From: Cllr. Jamie Bennett
Sent: 27 August 2019 12:43
To: Zac Denton <Zac.Denton@arun.gov.uk>
Subject: Fwd: Chairman's Discretion in regard to EP/74/19/HH & K/19/19/HH

EP/74/19/HH no 2 Hilview Crescent occupies a prominent position at the corner of Hillview Crescent and Orchard Road. The proposed addition of a large "dormer" extension to the roof of the existing single story bungalow would be incongruous and discordant in regard to the existing street scene creating discordant "mass" in relation to the character and appearance of the host dwelling and to the immediate locality. It would also introduce an unacceptable level of overlooking not only in Hillview Crescent but also in Orchard Road and Chiltern Close.

K/19/19/HH Little Tangle, Kingston Gorse. The proposed development involves more than a simple extension to the existing property. The proposal involves raising the roof height to 15.4 metres creating a new dwelling level at first floor height and adding a balcony at that level. This would result in significant overlooking of the properties and gardens on either side of Little Tangle and there is no evidence in the application as to how this might be avoided or mitigated. A

Proposed Elevations

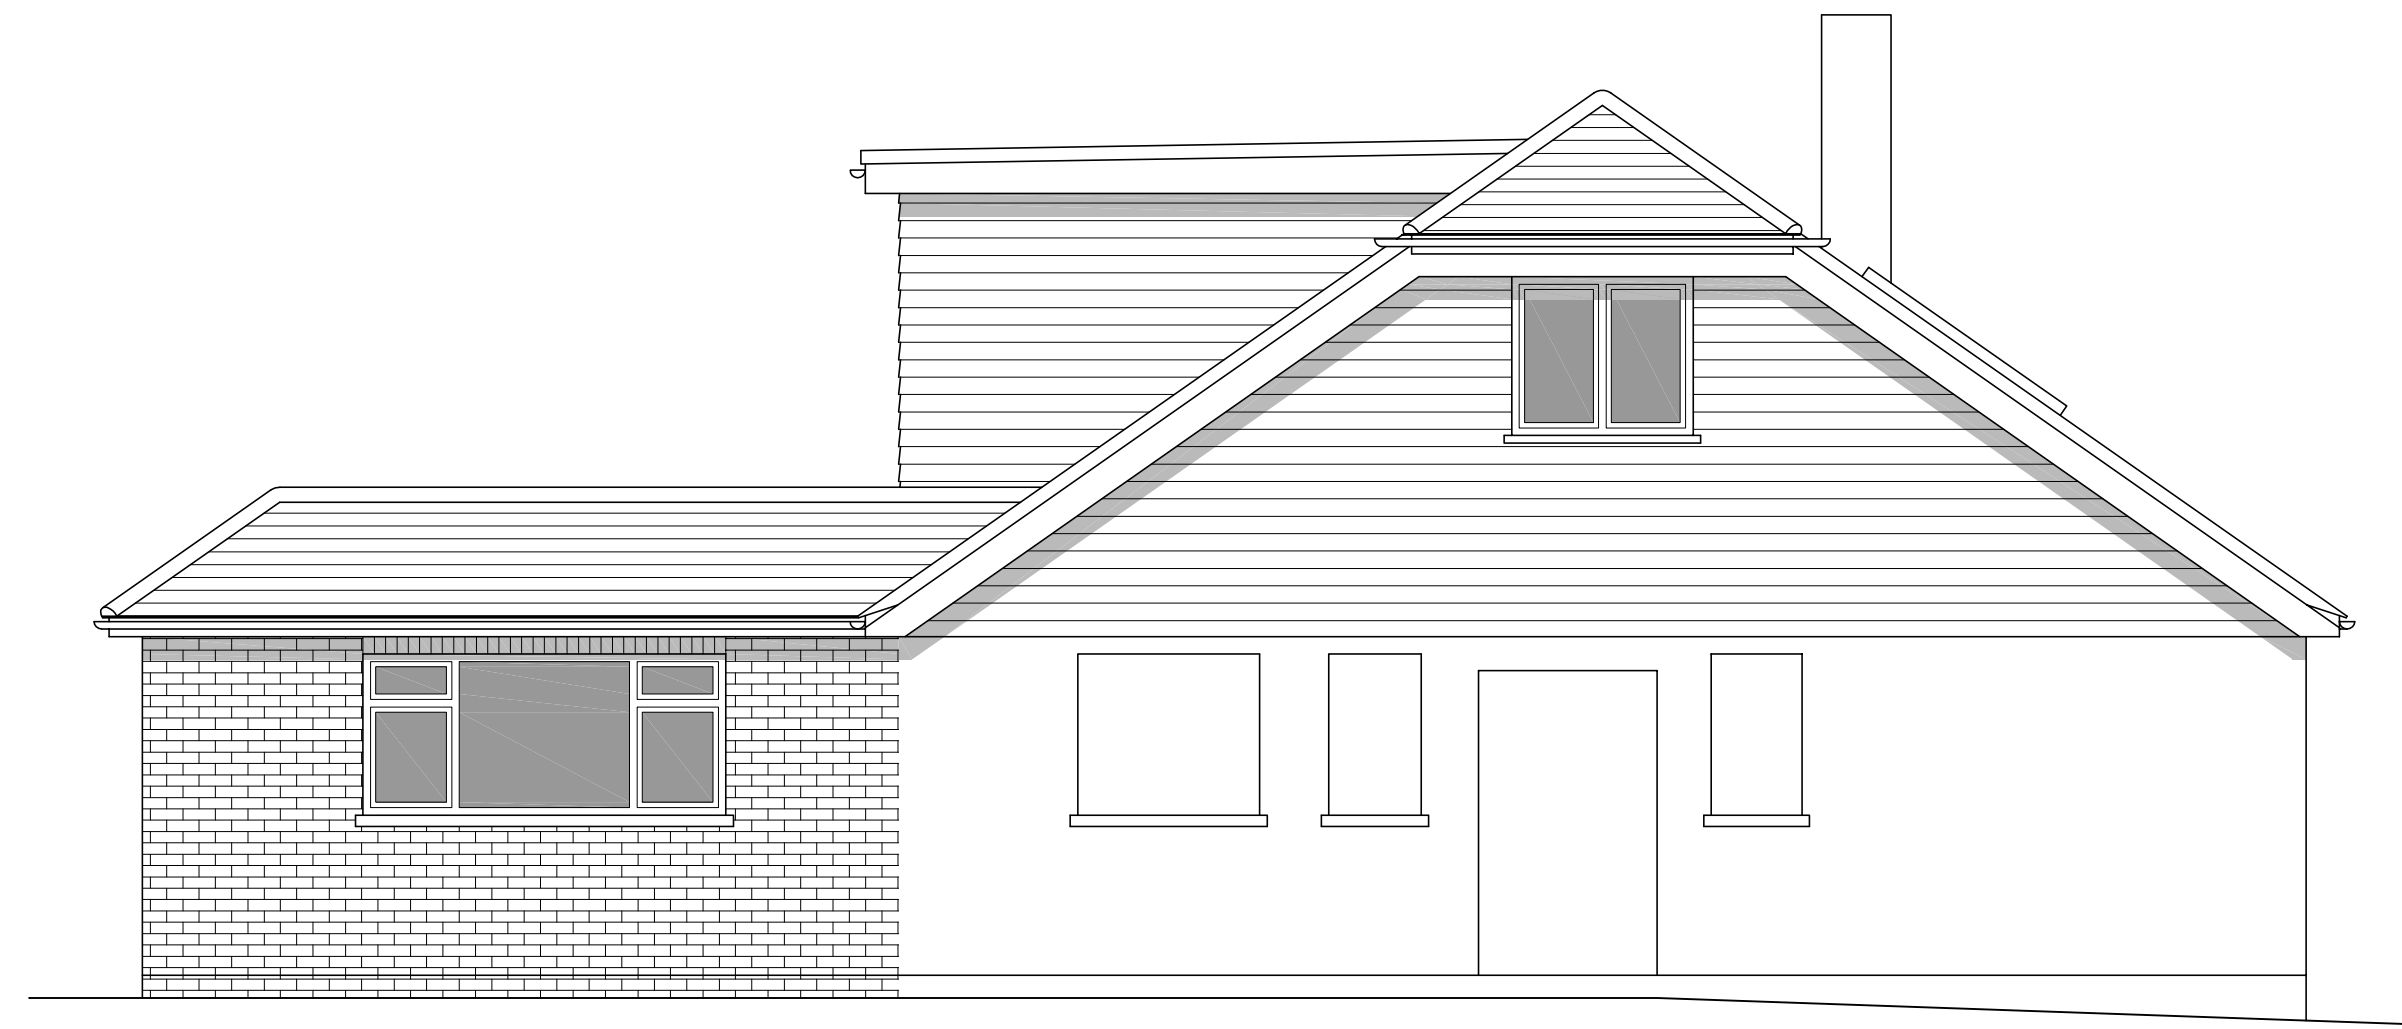
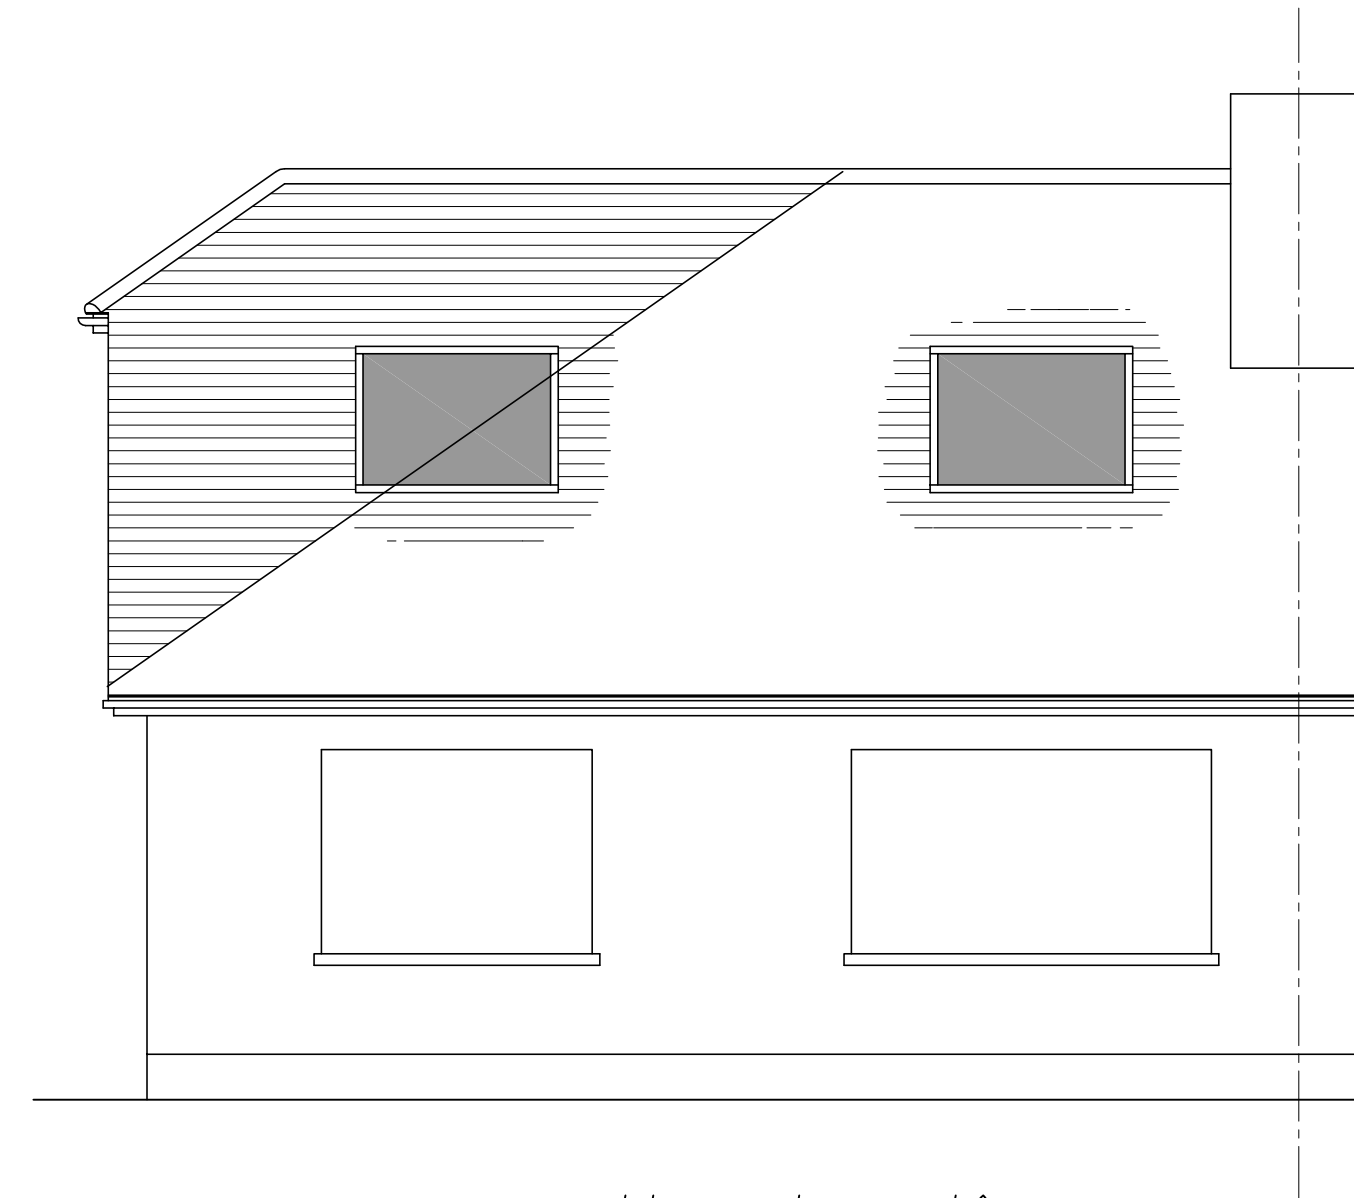
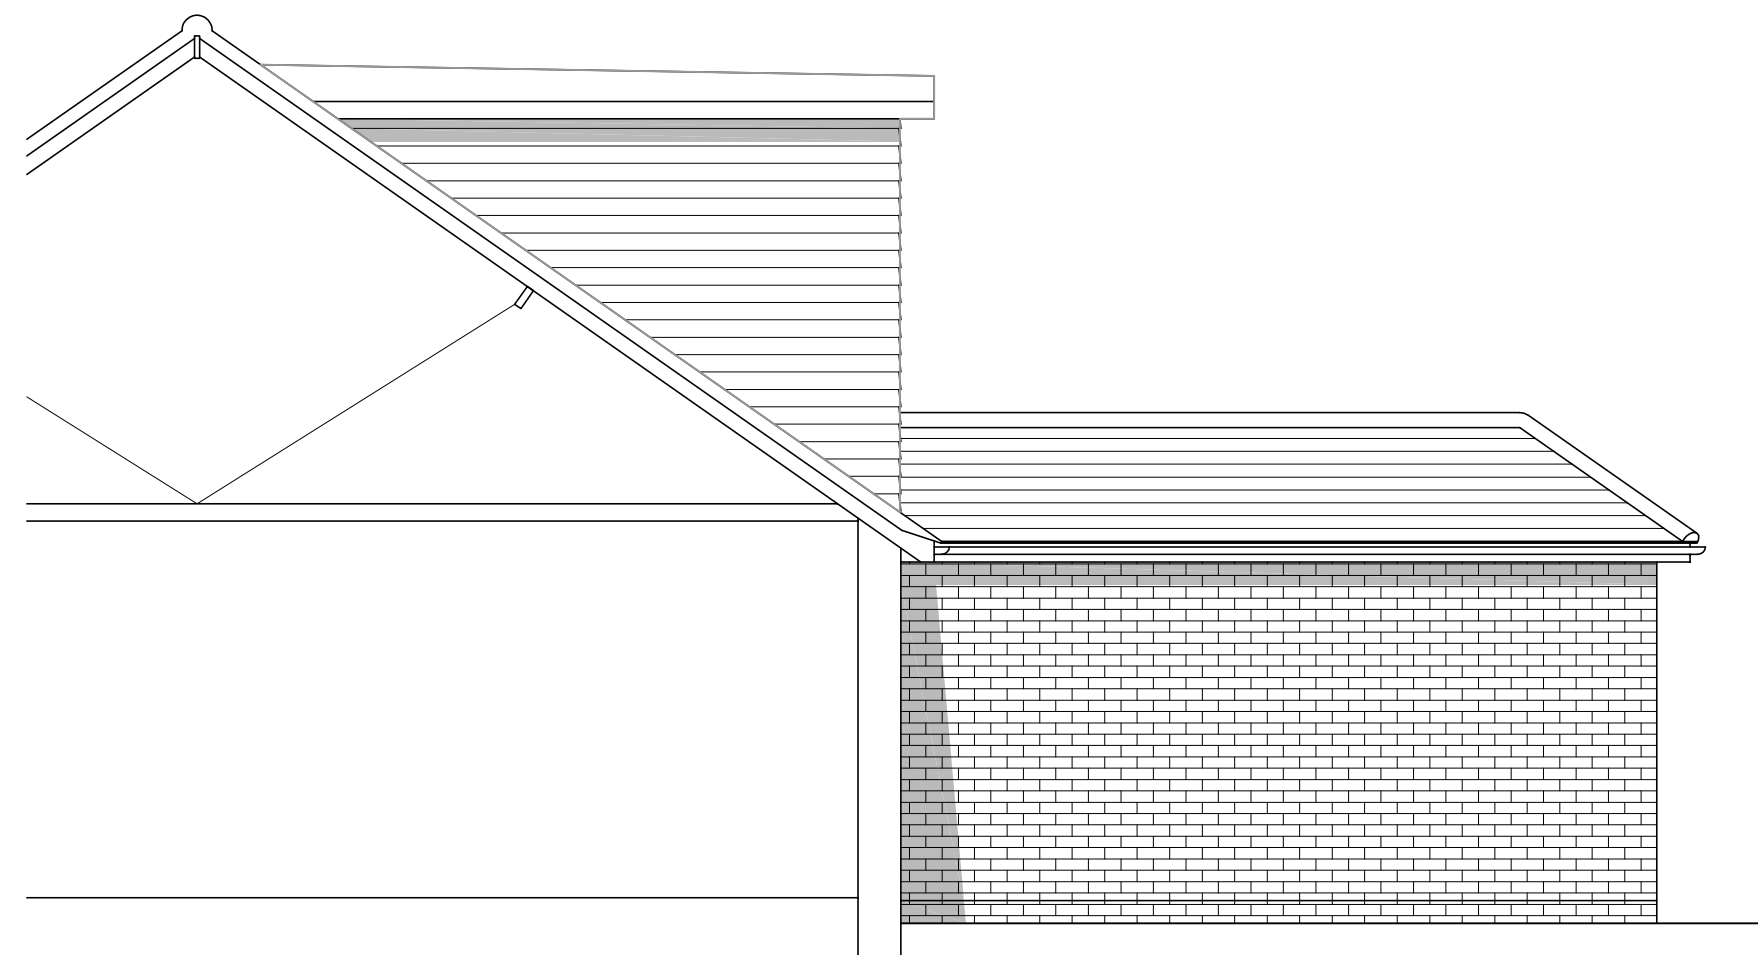
To my mind the application as it stands is contrary to policies D DM1 and DM4 of the Arun Local Plan and Policies 1 and 3 of the East Preston Neighbourhood Plan.
